Our ref: SSD-7709-PA-224

**Subject: Moorebank Precinct West - Stage 2 (SSD-7709)
Swept Path Plans, Condition B85**

CONCURRENT A-DOUBLE & B99 VEHICLE MANOEUVRE
1:250 SCALE

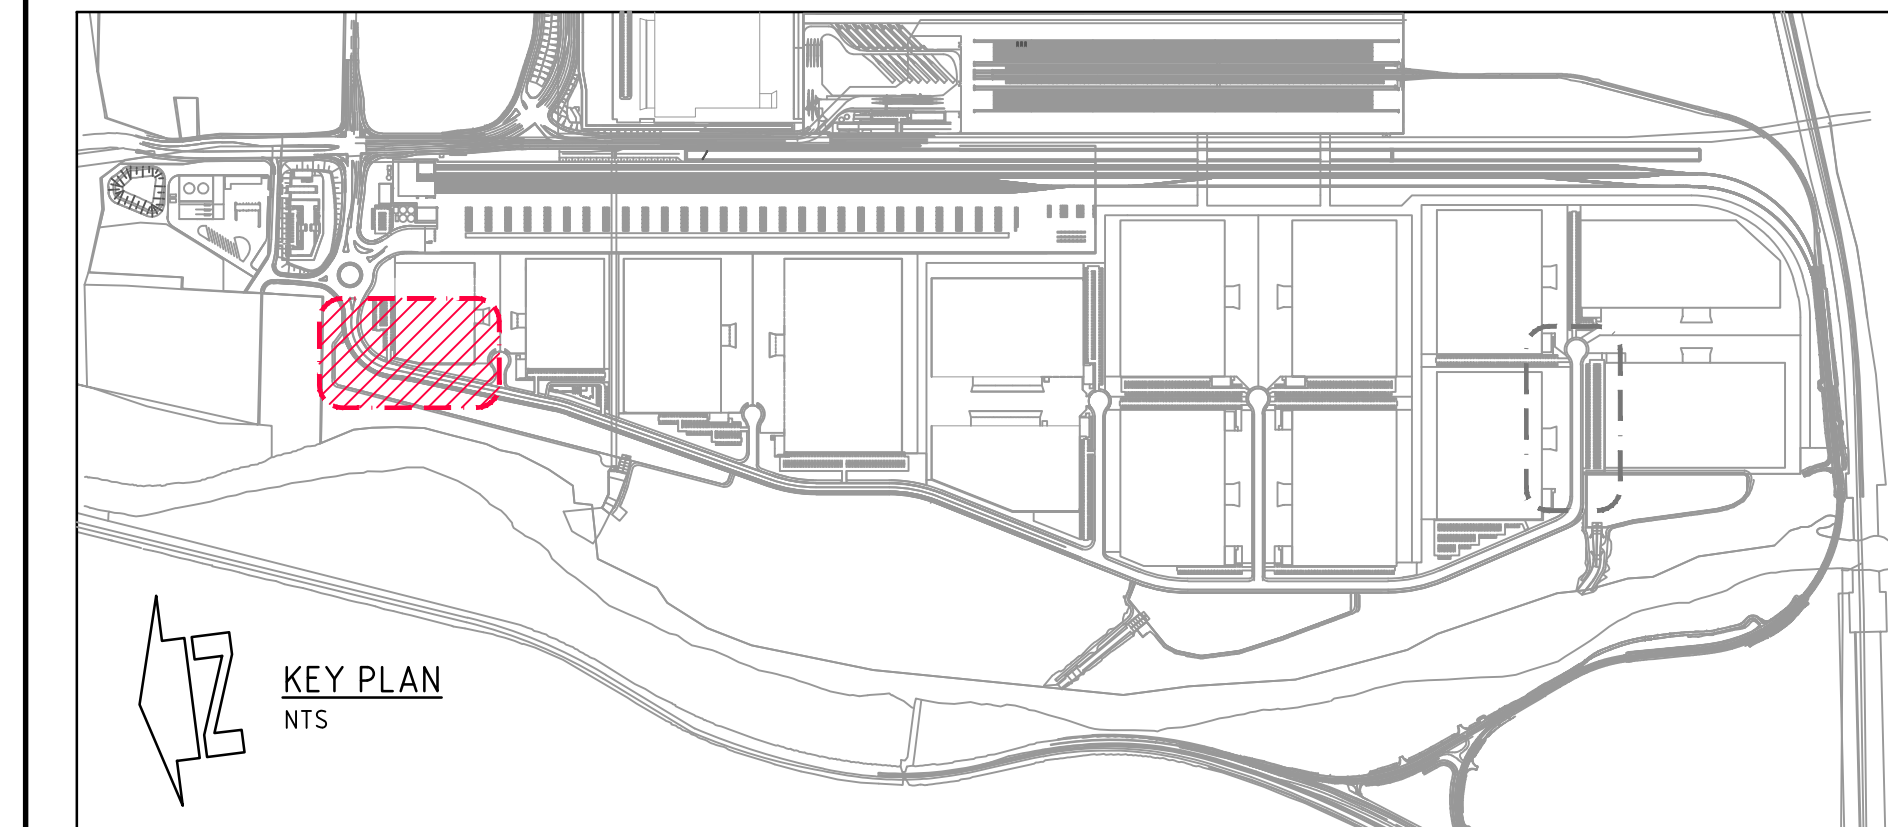
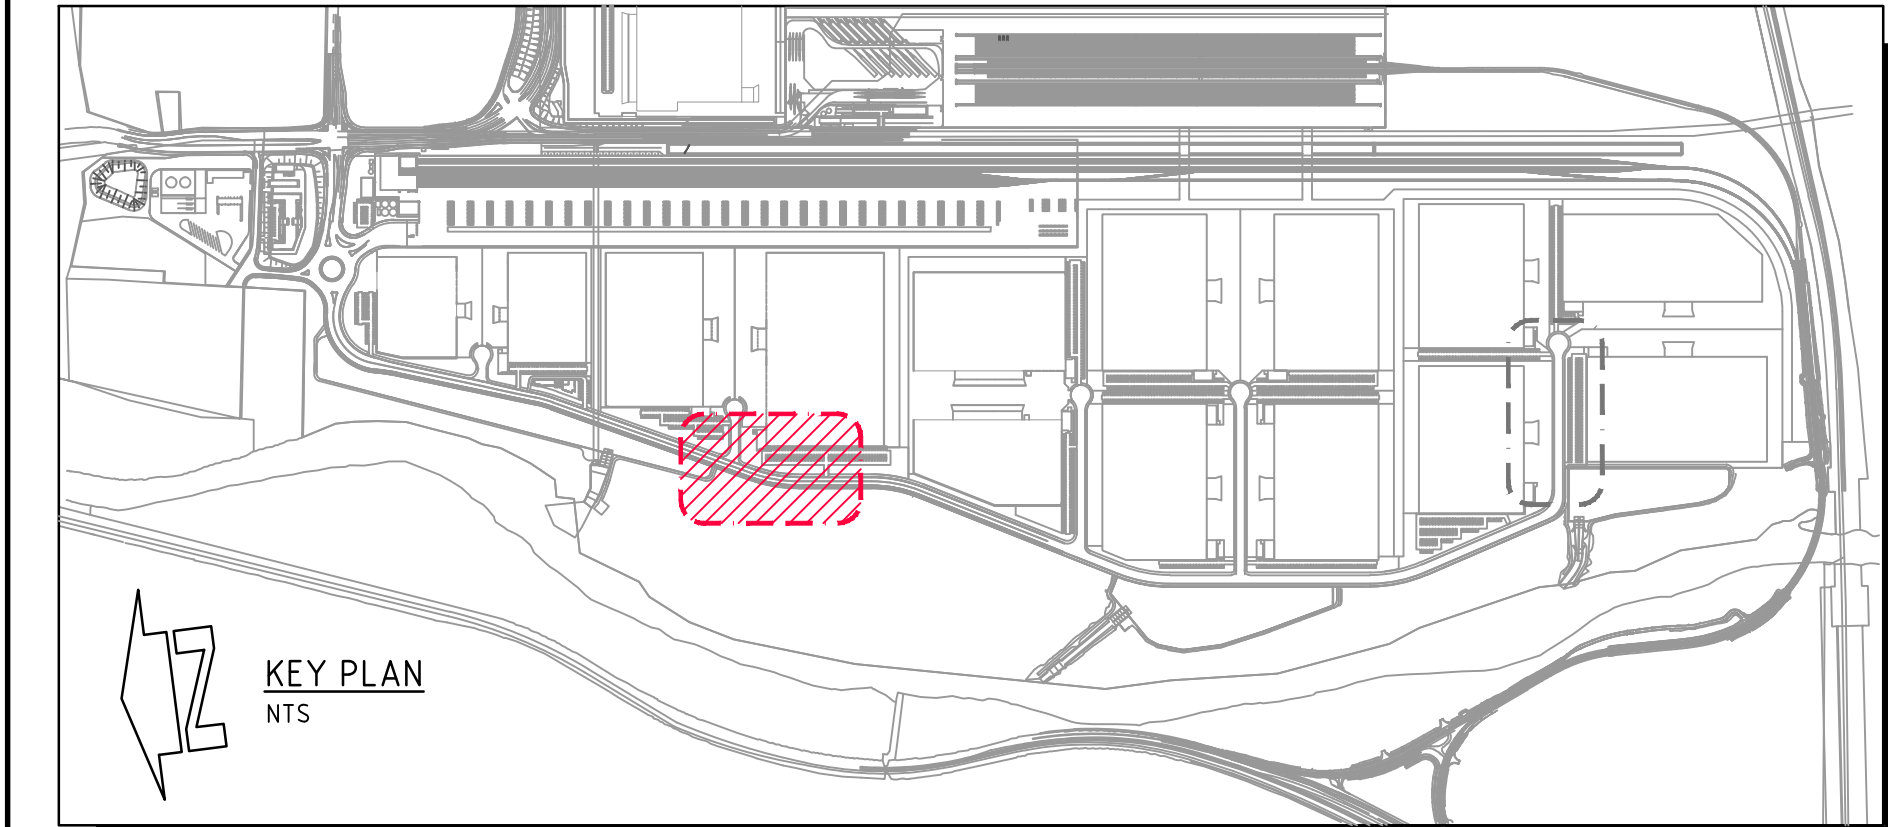
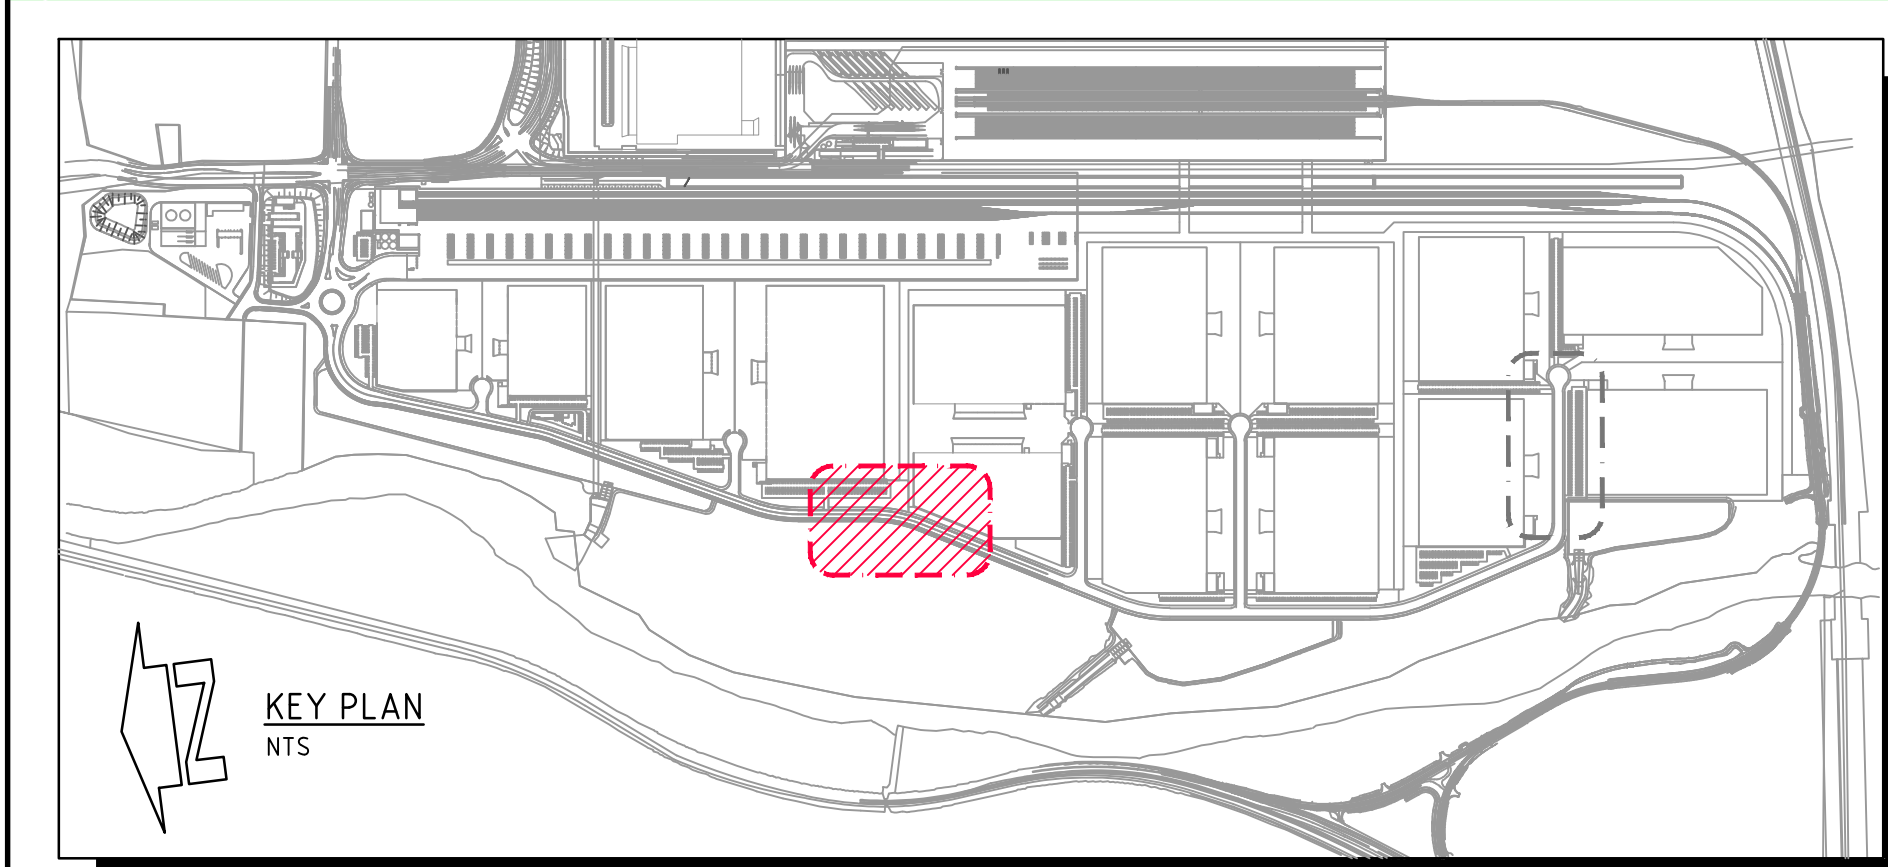
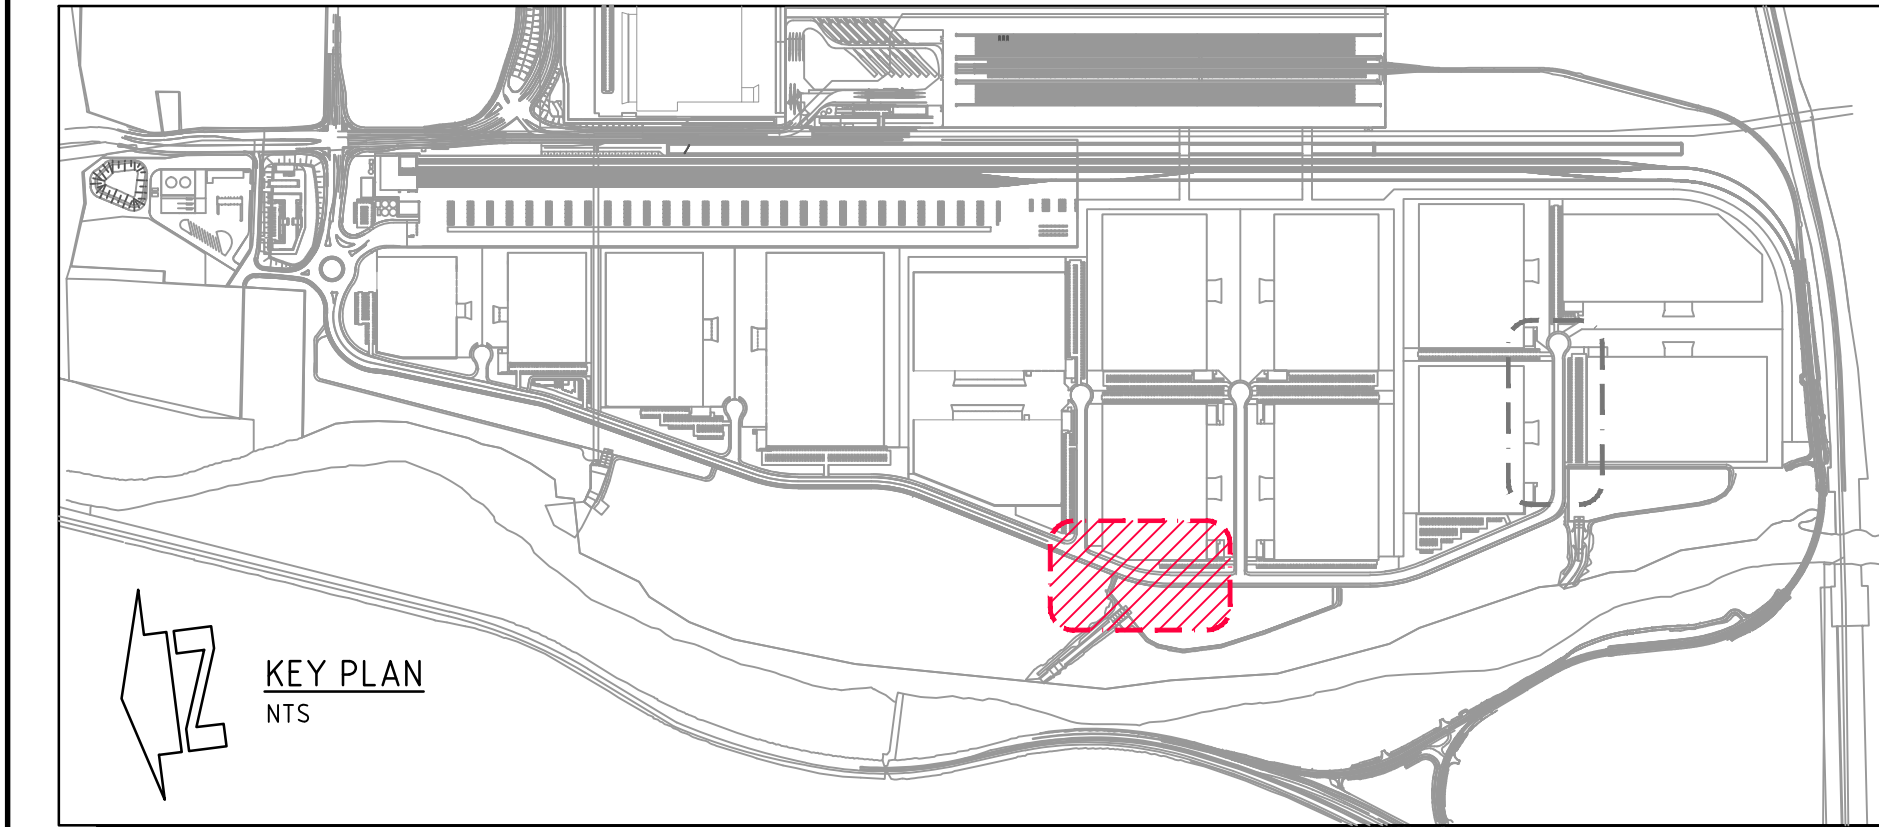
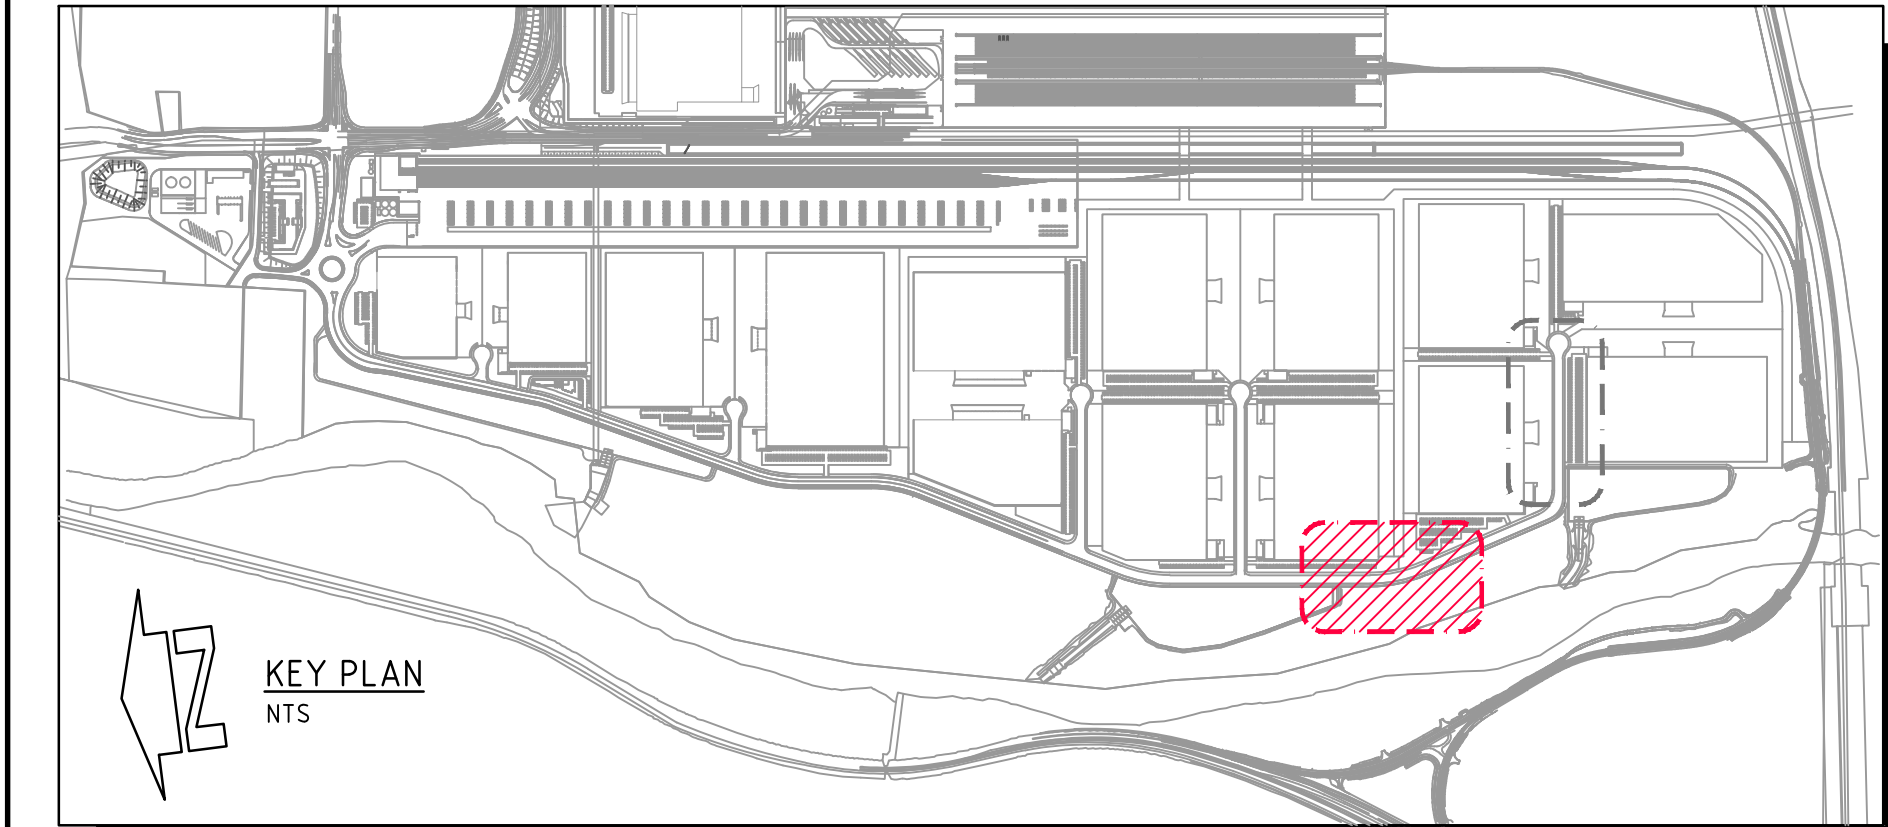
I remind you to ensure that the internal site swept paths for three (3) cul-de-sacs are also required to meet the requirements of condition B85. Also, I remind you to remove 'For information' from the Precinct Road Swept path plans (see Attachment 1) and submit the final plans to the Department for our record.
